**A122 LOWER THAMES CROSSING (REF: TR010032)
DEADLINE 6 WRITTEN REPRESENTATIONS**

E AND K BENTON LIMITED (AP1717)

Plate 59

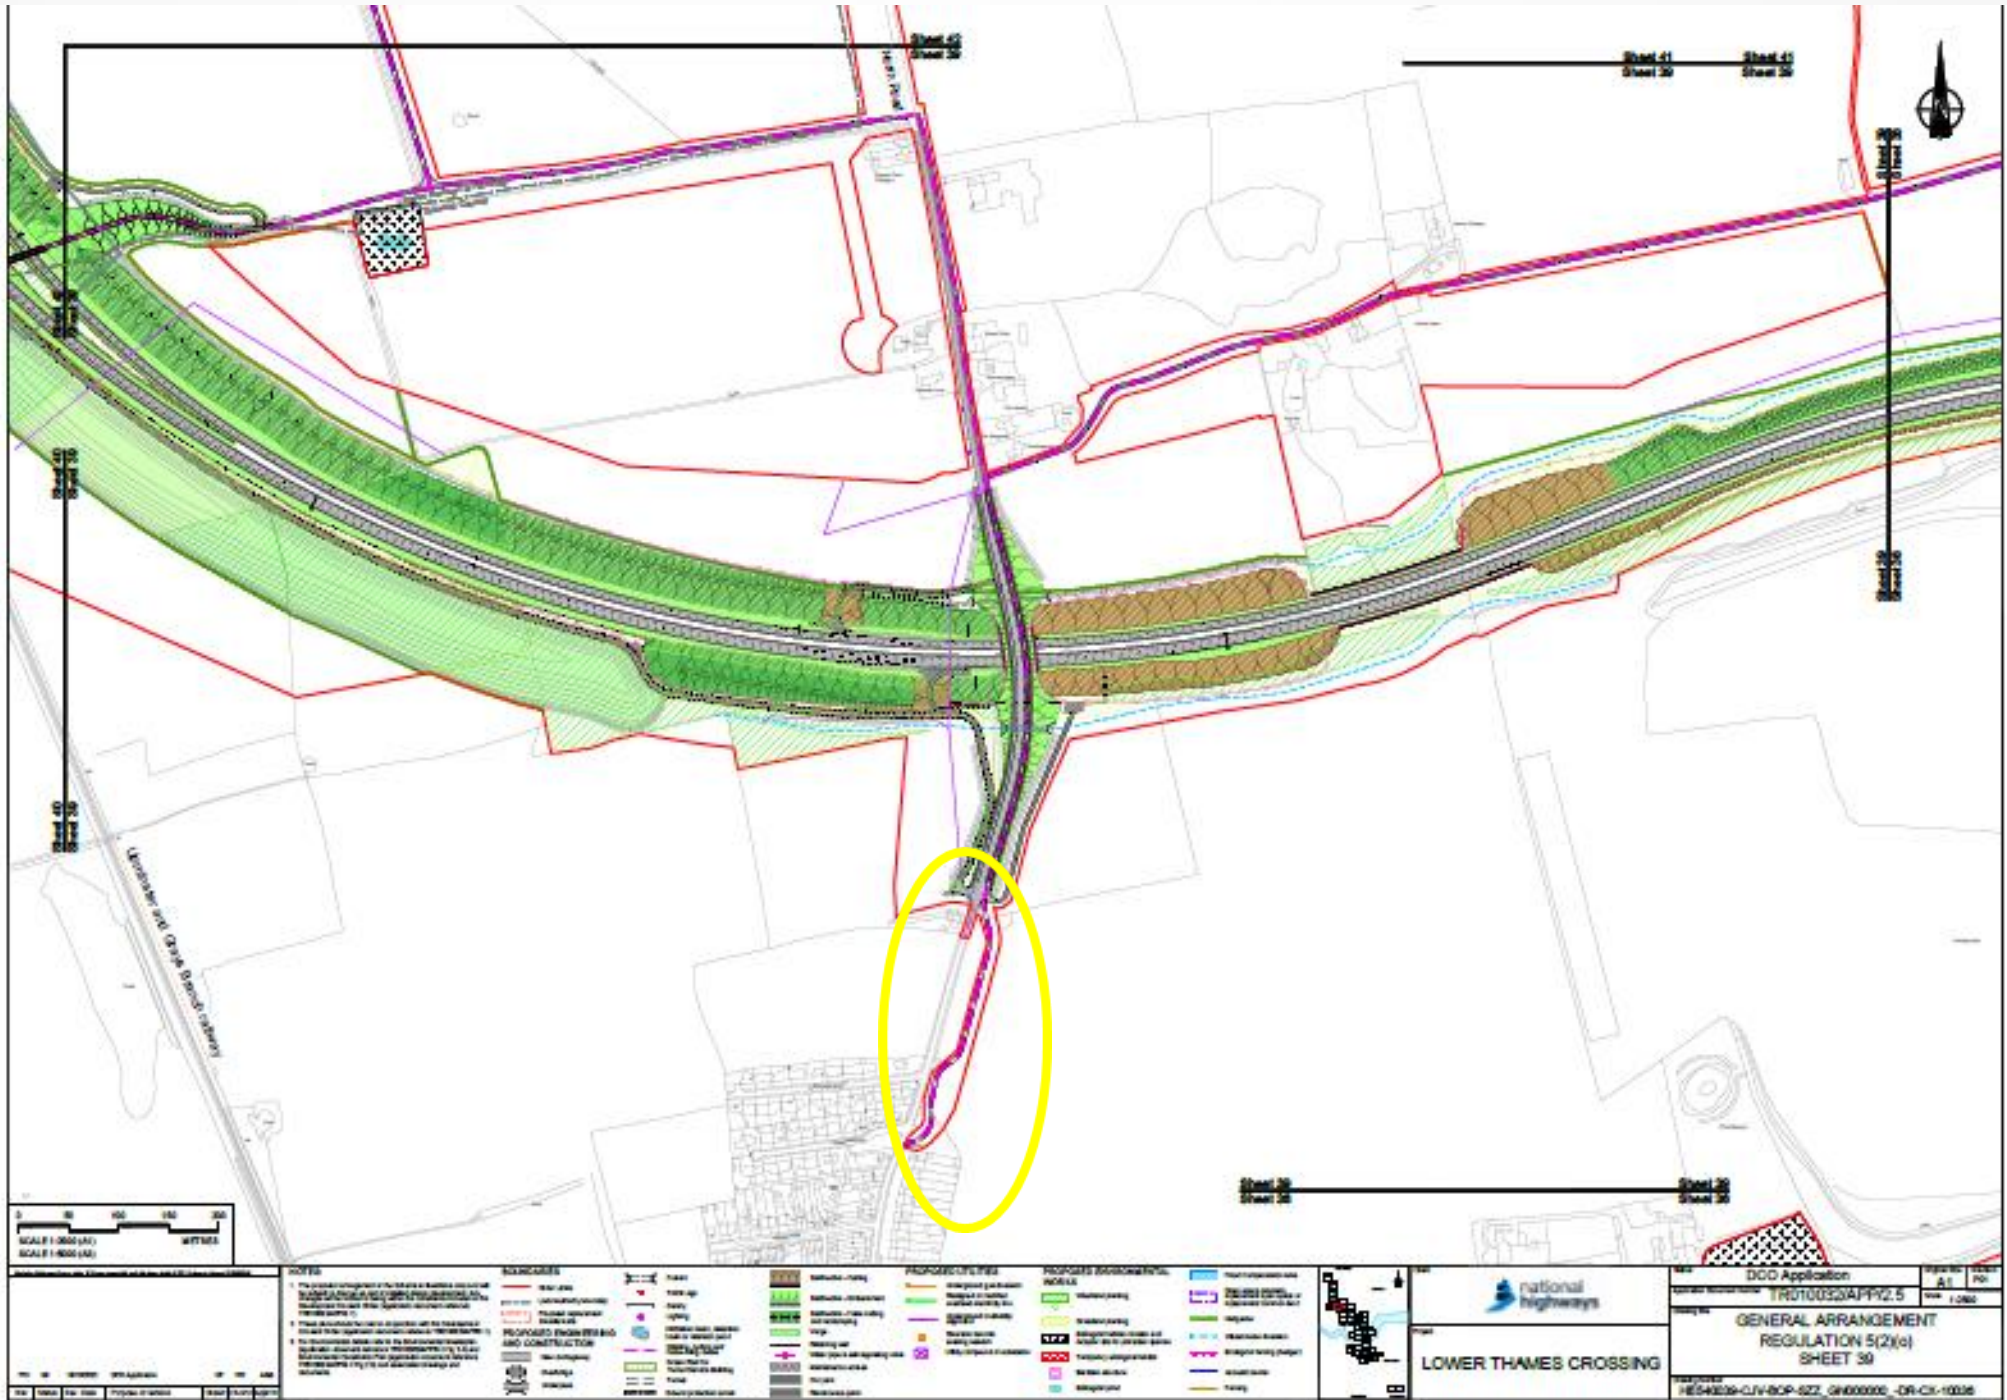
<p>WCH Routes</p>	<p>Plate 57 - is an extract of the Applicant’s WCH route plans from REP2- 074 and show the existing rights of way</p> <p>Plate 58 – is an extract of the Applicant’s WCH route plans from REP2- 074 and show the existing & proposed rights of way</p> <p>Plate 59 - shows the WCH route on the east side of North Road</p> <p>Plate 60 - shows the North Road route on the Applicant’s general arrangement plan</p>
